Subject: Shoreline Exemption Permit (SX-22-00018 Lauckhart) – Deemed Incomplete – Request for Additional Information

LAUGHART DECK REP.
232 MOUNTAIN VIEW LANE
EASTON WA, 98925

SITE PLAN

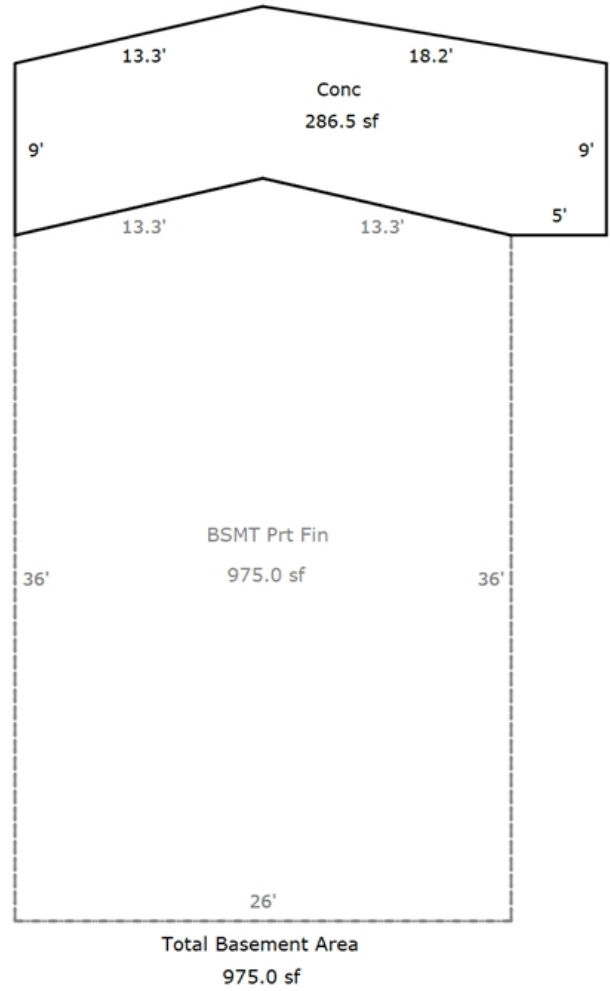
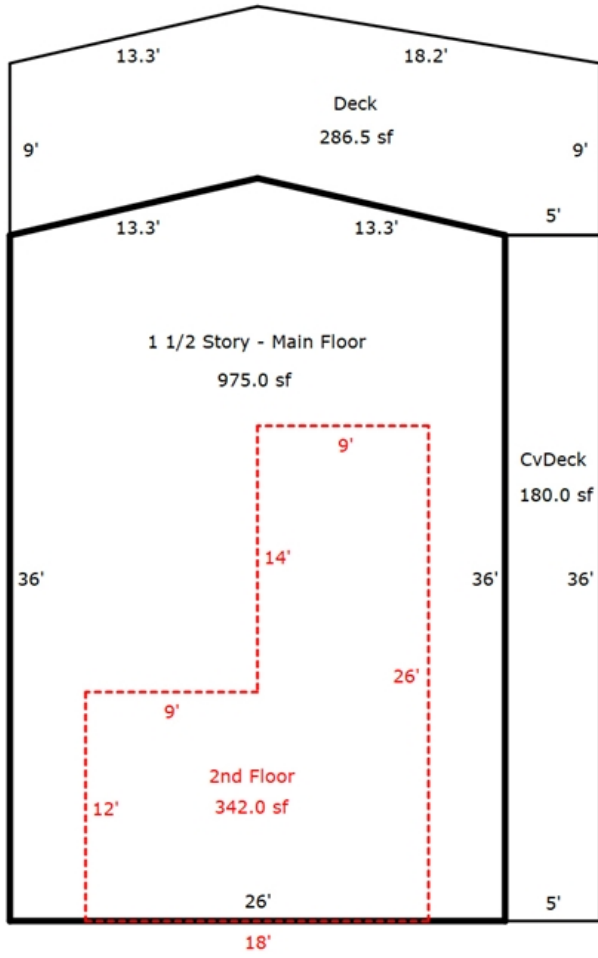
1. Please provide clarification on what appears to be an addition to the existing structure. The area of concern has been identified on the attached documents.

I have attached a copy of your submitted site plan with the area of concern identified. Additionally, I have provided a copy of the Assessor's sketch and a copy of a site plan from a 2019 building permit (BP-19-00850), both of which do not show the area of concern as is seen in your recently submitted site plan.

Does not appear in
previously provided
building permit site
plans or on
Assessor's sketch.
Please provide
clarification.
